Conservation Comments Response

Subject: 2023 0165 Erection two Storey Dwelling Land Rear of 207 – 209 Manchester Road Thurlstone

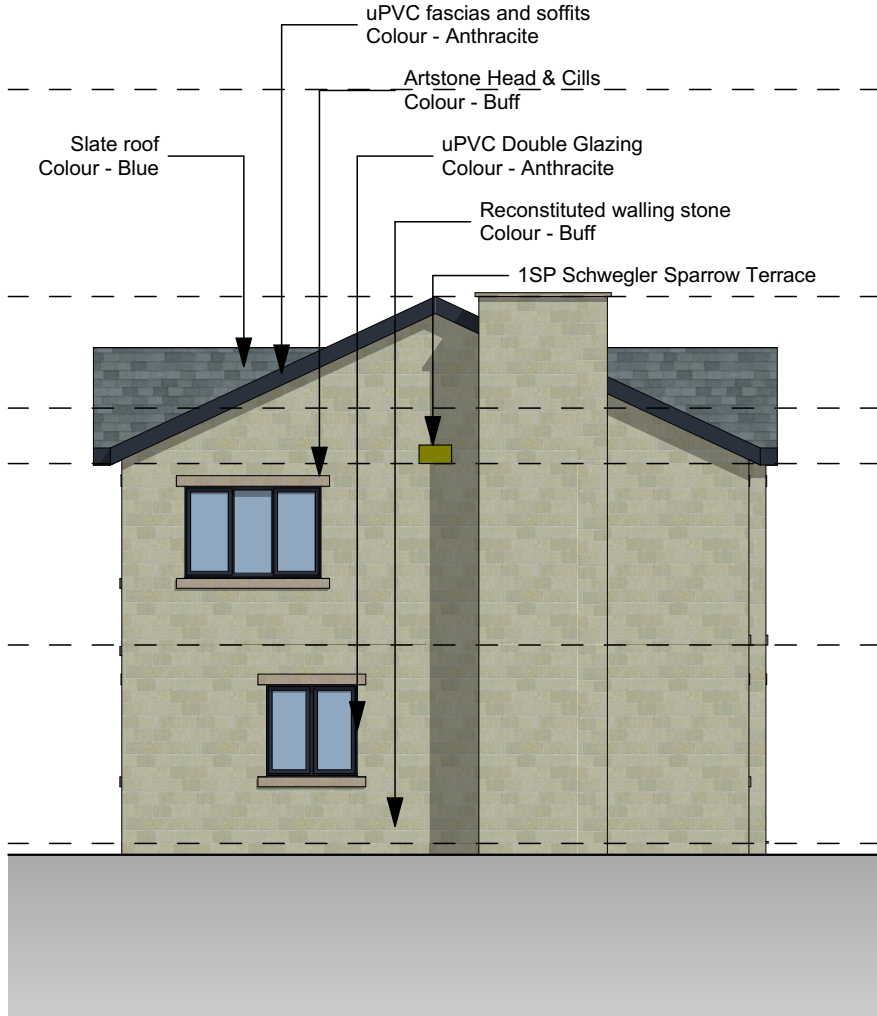
The design submitted in this application is substantially different and is generally more restrained than the one submitted at pre-app. The use of more conventional forms, details, and materials are an improvement. The scaling of some of the fenestration is on the excessive side with large floor to ceiling glazing not being the norm in the conservation area. However, the overall design of the envelope, the use of re-constituted stone, slate and Artstone detailing is a relative positive in this setting. In isolation I would have few problems over such a design, however the impact in this location is critical to understand. Due to the elevated nature of the site and the impact this will have on the setting of the former Wesleyan chapel, the listed St Saviours Church, and the wider conservation area I'm afraid I do have concerns. This relates to the overbearing nature and scale of the south facing elevation, its glazing, and the degree of visibility and the relative isolation of the development when viewed from the south. I am aware there are dwellings to the east along High Bank Lane that are suggested to be similar in terms of their setting and impact. These include 155 to 161 High Bank which are historic and include an element of three storeys. I'm also aware of the recent development on land adjacent to 149 High Bank. This dwelling appears as a single storey structure when viewed from High Bank Lane but extends to two storeys to the south owing to the gradient. However, I would argue these houses are located much further east towards the historic core of the settlement and are 170m east of the proposal site. They represent the natural continuation of the pattern of historic development travelling east to west from the junction with Hedge Hill Road. It is also worth noting existing development stops at number 161 with a significant pinch point on High Bank Lane at number 157. Importantly, the road continues to rise towards the west as it traverses the slope and as a result, the proposal site is more elevated and more visible. Further differences include the sensitivity of the heritage setting already described (including that of St Saviours and the Methodist Chapel at 213). This setting goes beyond simple intervisibility and includes views from Manchester Road where the proposal site and the designated NDHA can be seen together. Consequently, I would suggest the setting and the impact of development is substantially different here and (on balance) this amounts to less than substantial harm. However, any harm requires clear and convincing justification and given the purely private benefit of the development I feel this is not demonstrated. A tandem concern relates to the question of the precedent which could be created if this application were approved. This may result in further proposals for backland developments to the rear of Manchester Road which would significantly alter the character of the conservation area as a result.

- i) These are namely that the proposal is a two storey form of construction, set at an upper level from Manchester Road due to the natural topography of the area, as is historically typical along the valley corridor, and that of the wider Thurlstone area see below.

- ii) In keeping materials and details have been used to suit the conservation area local vernacular. These are namely that the proposals are stone (or reconstituted stone)

built, with a slate roof and stone feature cills and lintels, as is typical of both historic and recent construction.
